Application no: 23/02338/OUT

Location: Land West Of Oxford Close And North Of Corner Farm, Station Road, Kirtlington

Transport Schedule

TITLE:  
**Proposed Site Access -  
Vertical Visibility Splays**

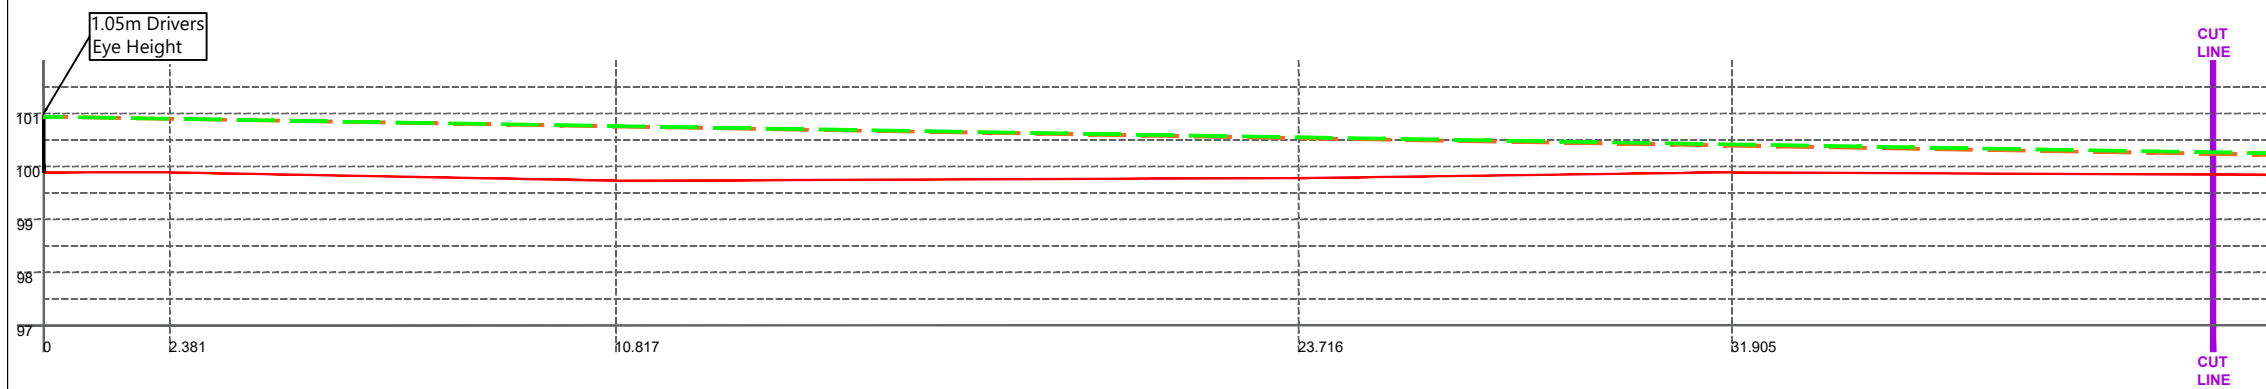
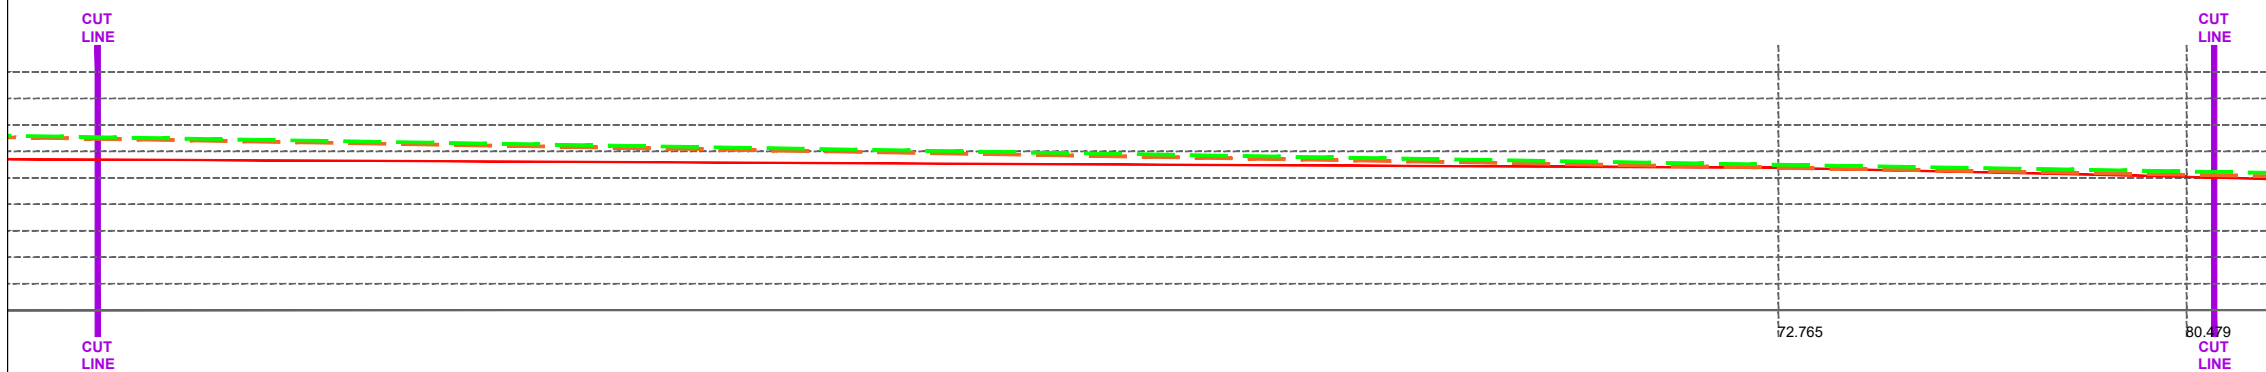
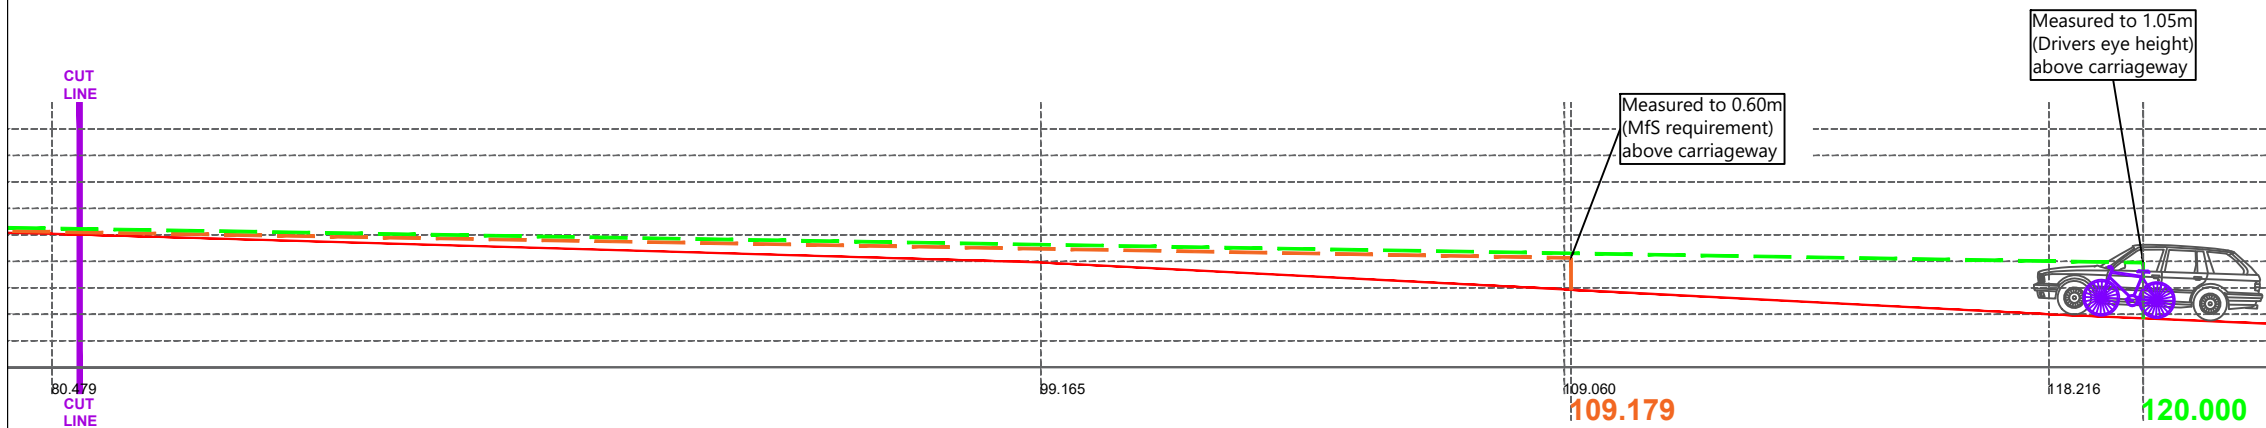
Access is proposed onto Lince Lane (A4095) immediately north of the existing 20mph speed limit sign, on the outside of a curve. The speed limit to the south is 50mph. The transport statement says there is a visibility splay of 2.4m x 120m to the south, with the sight line crossing the opposite verge on the inside of the curve. However, having revisited the site, we find this is not achievable, due to the gradient and vegetation. Visibility measured along the edge of the northbound carriageway is between 90 and 100m. Therefore, the drawing is misleading in our opinion, and this is a **reason for objection**.

- The drawing should be resubmitted showing the achievable visibility splays, together with the speed survey data and a Stage 1 Road Safety Audit (RSA1) in accordance with GG119 (5.46.1) A Designers Response should accompany the RSA1 with the Overseeing Organisation agreeing and signing off the RSA.

Drawing Title:  
**PROPOSED SITE PLAN:  
Means of Access  
For Consideration  
only**

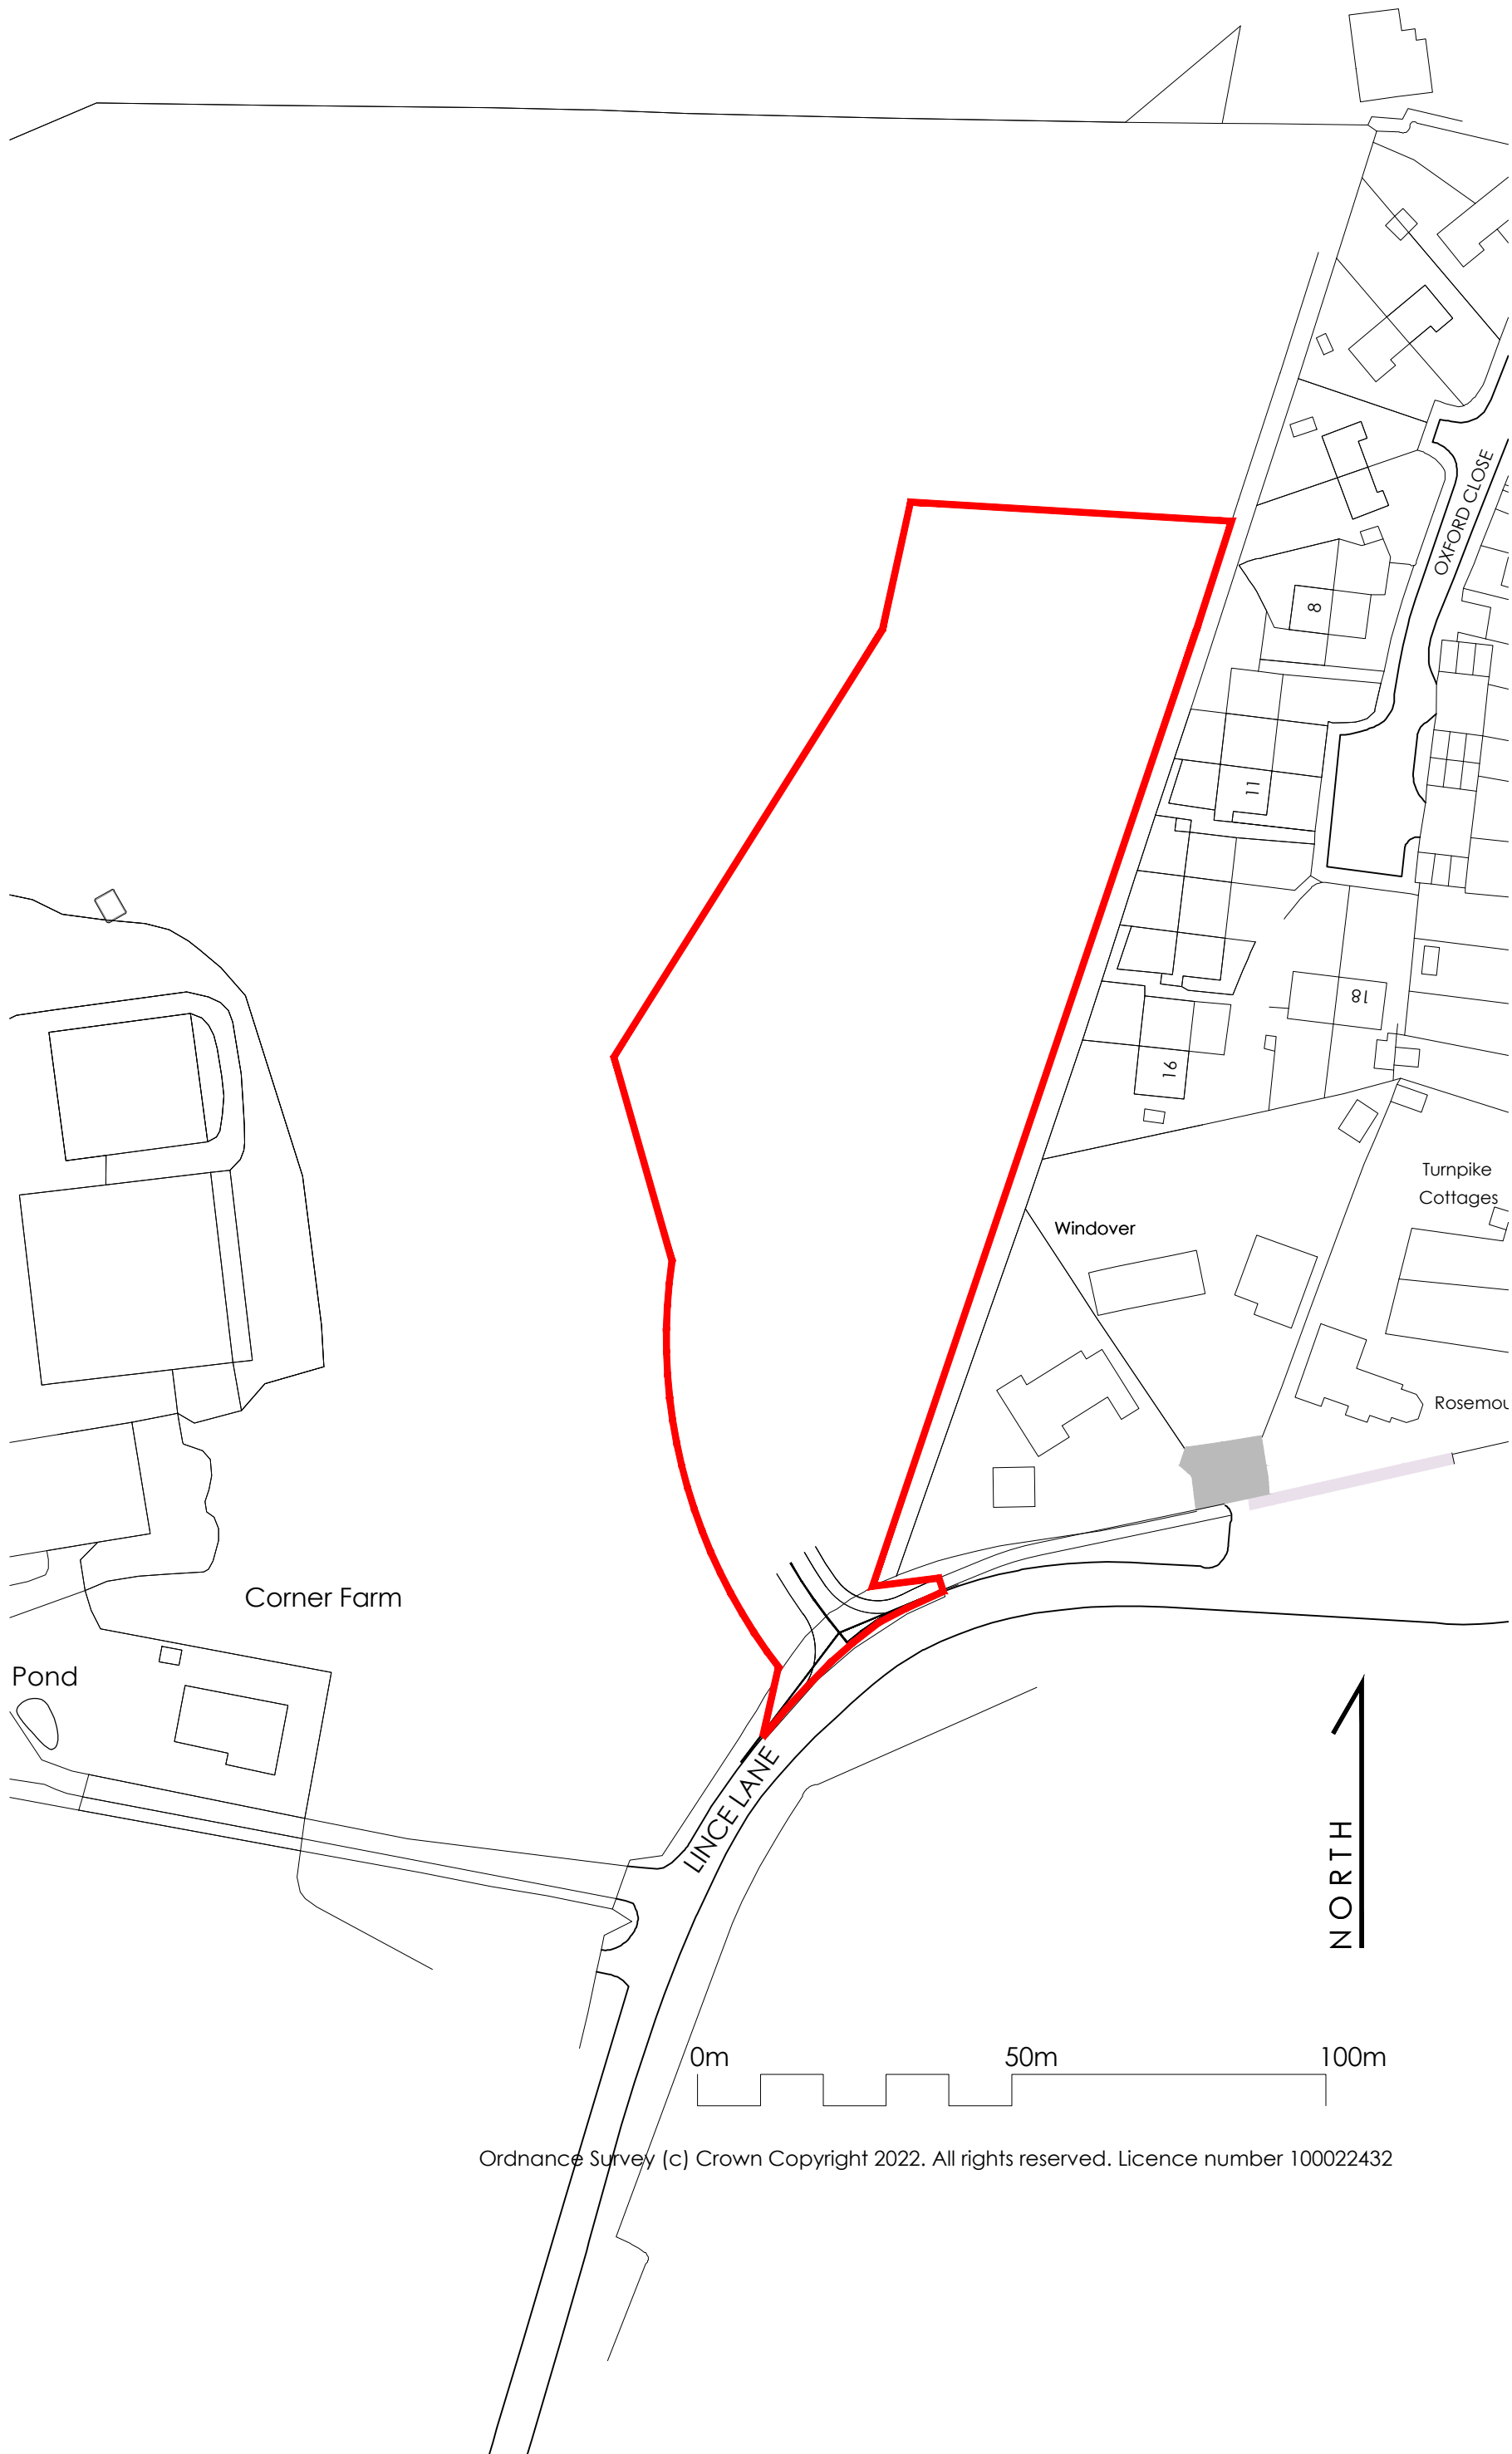
The application proposes to provide a 2m footpath into the site, and to extend this along the verge, linking to the existing footpath towards the village. The existing footpath is in need of improvement further towards the village, opposite the junction with Bletchington road, where there is a small unsurfaced gap. This should be improved as part of the S278 works, to provide a continuous walking route.
